OFFICIAL NOTICE OF DECISION

CITY OF ALBUQUERQUE
PLANNING DEPARTMENT
DEVELOPMENT REVIEW BOARD

3. Project # 1002567

ADVANCED ENGINEERING & CONSULTING LLC agent(s) for STEVE KIRK request(s) the above action(s) for all or a portion of Lot(s) 5-A-1, COLEMAN ADDITION (to be known as **HACIENDA DE LOIS SUBDIVISION**) zoned R-2 residential zone, located on 12TH ST NW, between MENAUL EXTENSION NW and LA POBLANA NW containing approximately 1 acre(s). [REF: 06DRB-00726] (H-13)

SECTION A-A
 NTS

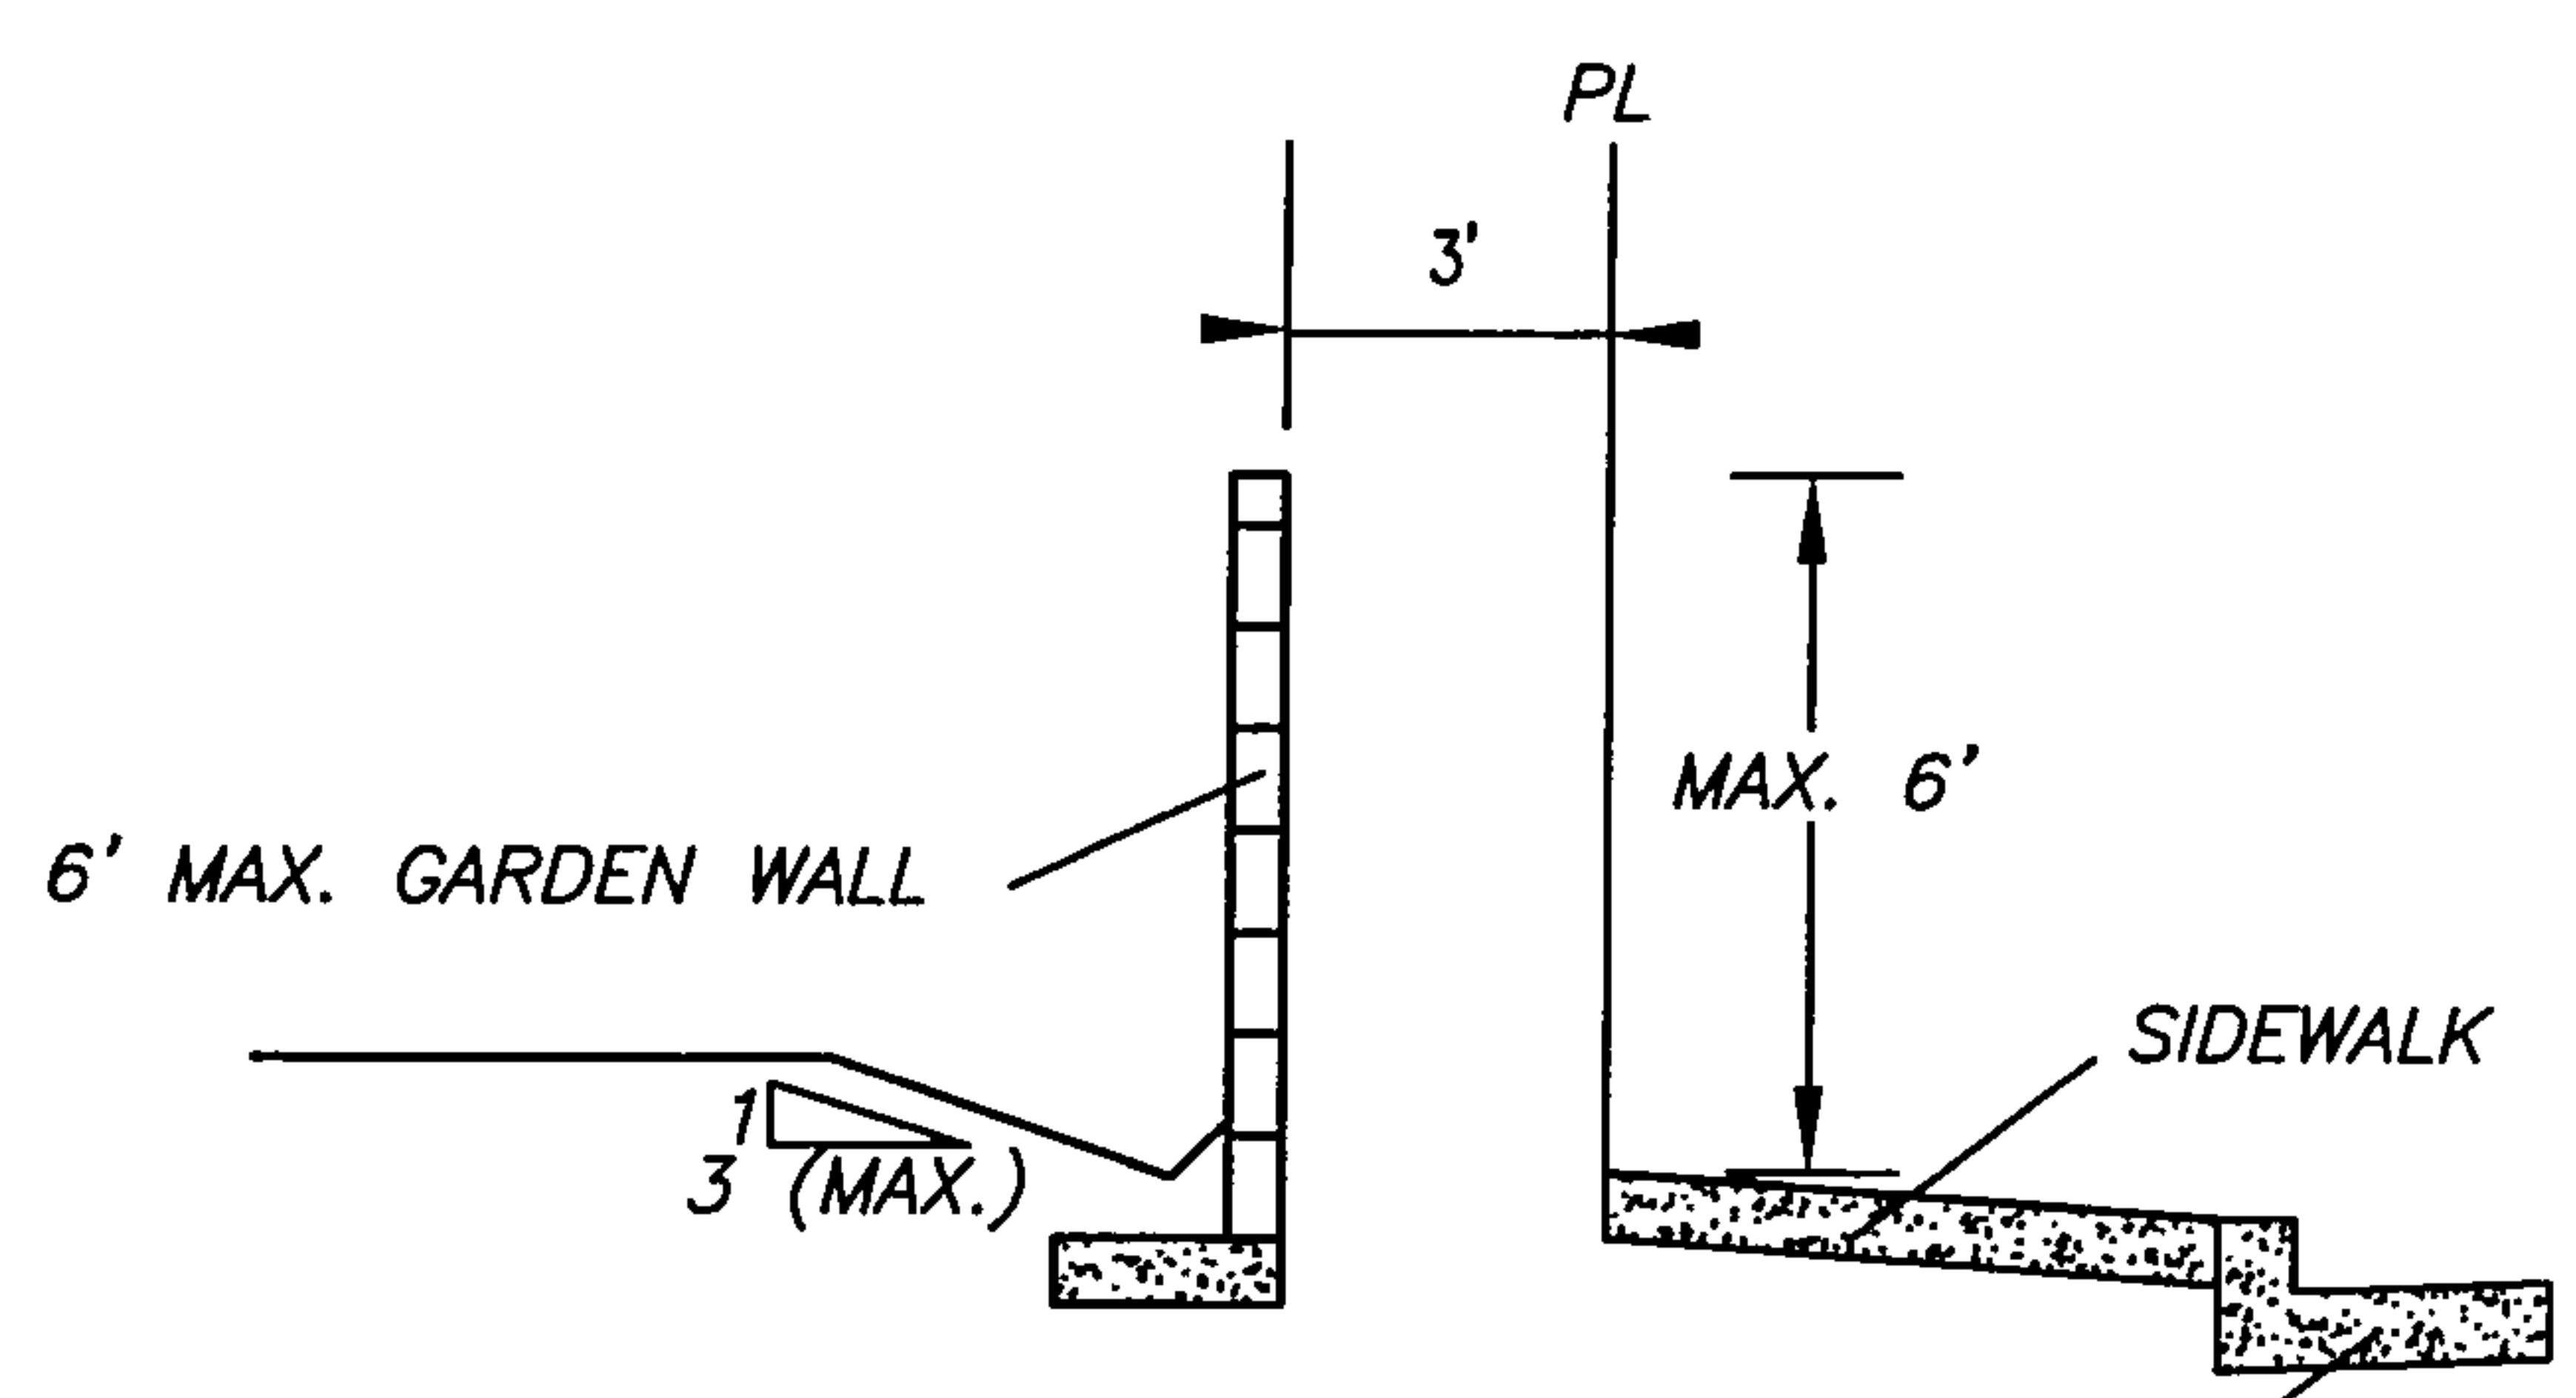
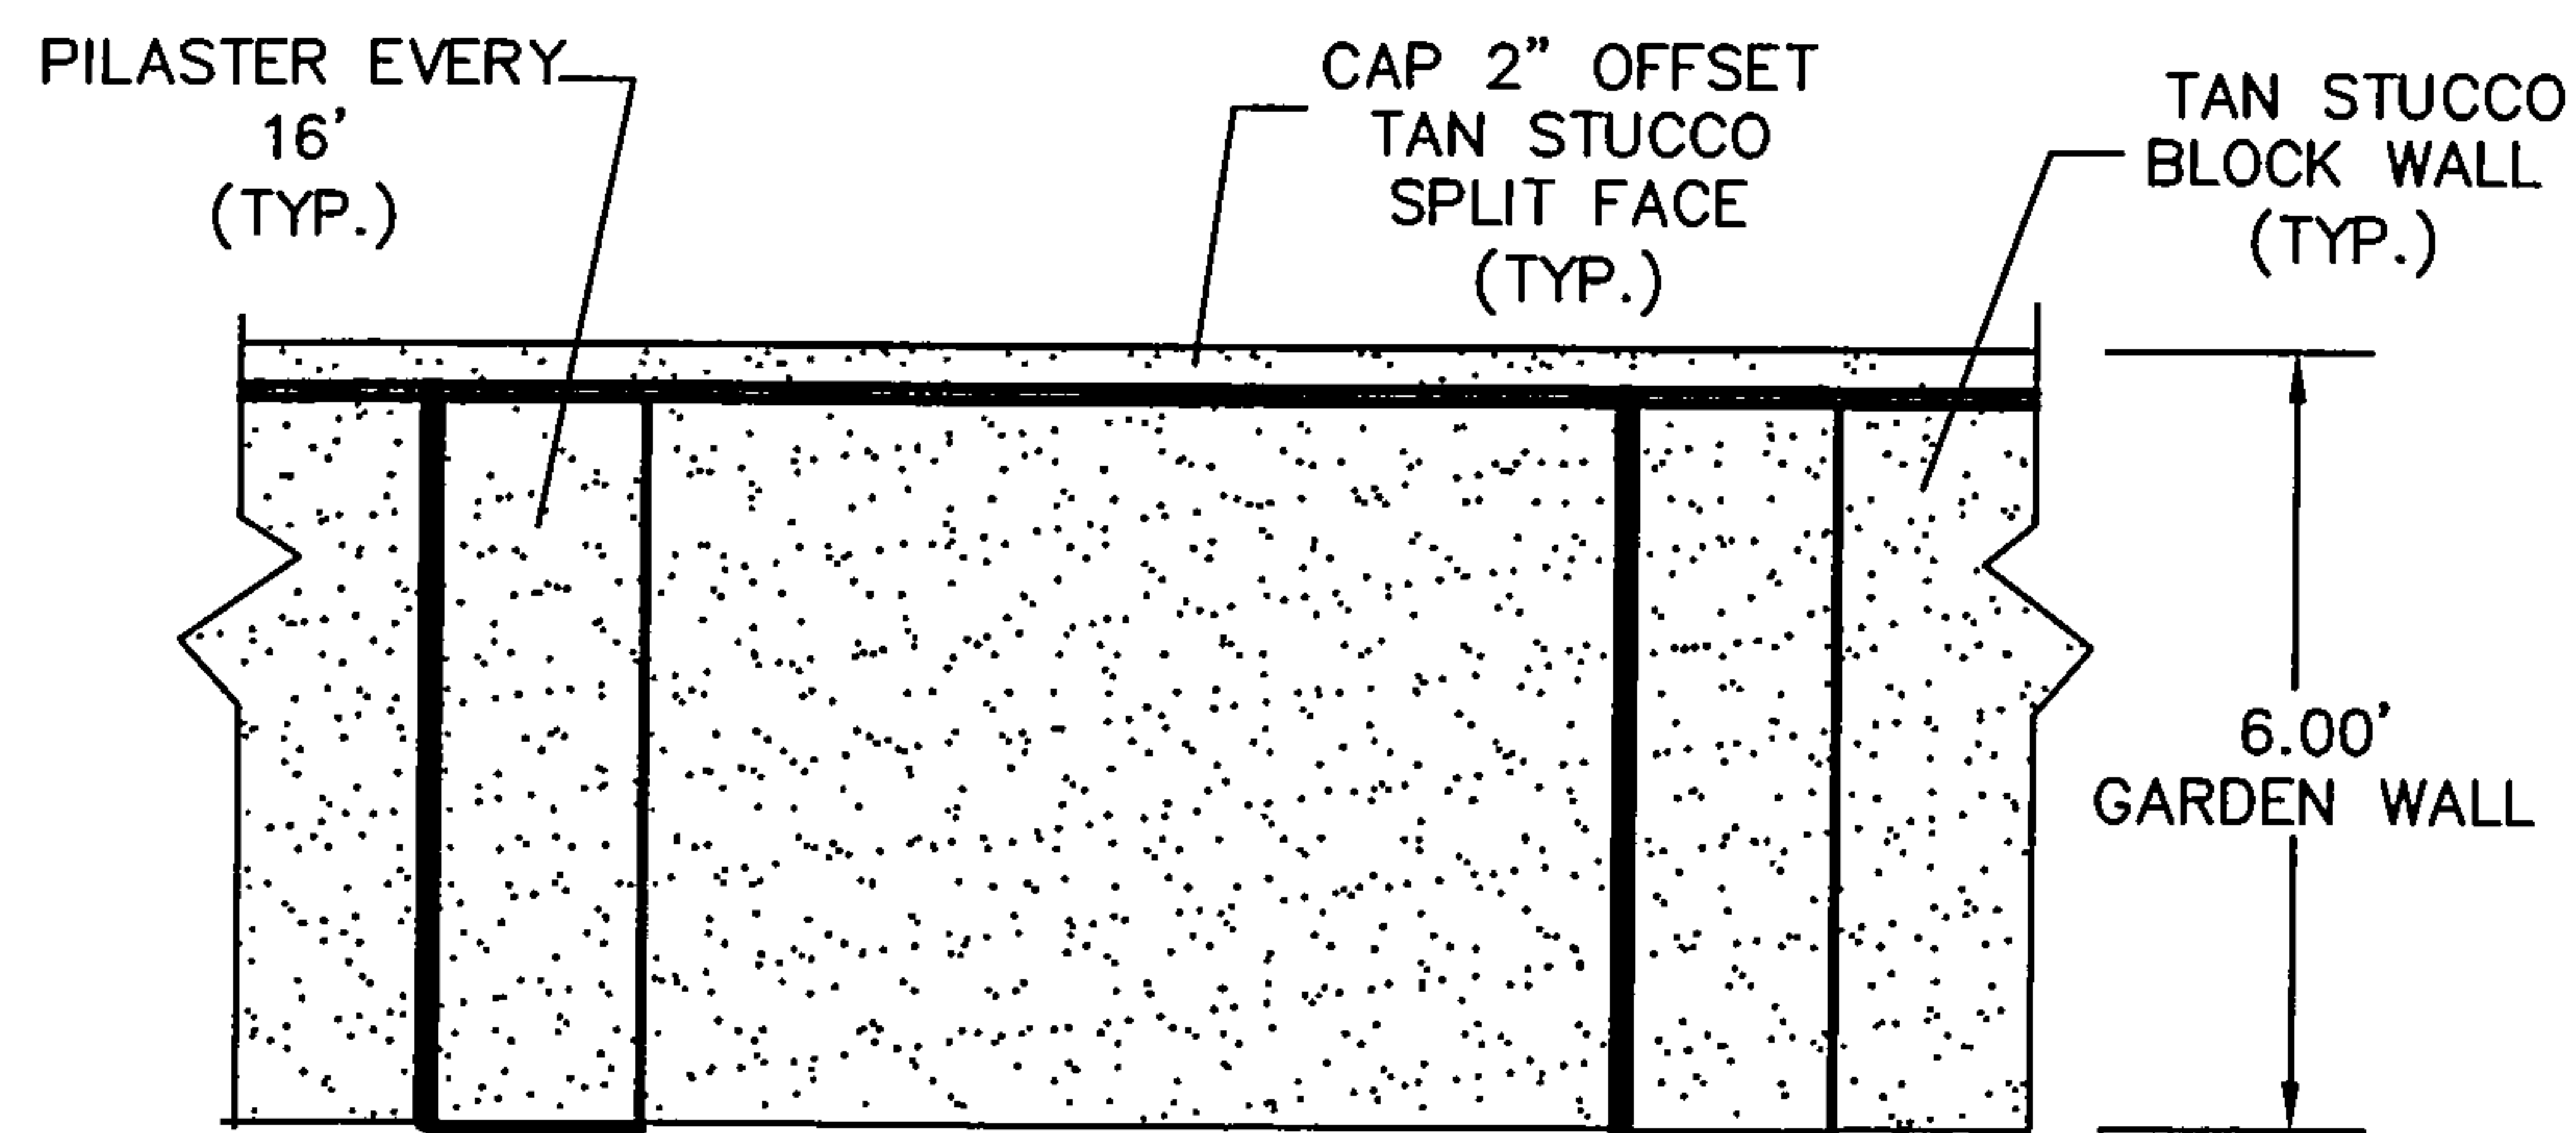
An improved wall design is needed,
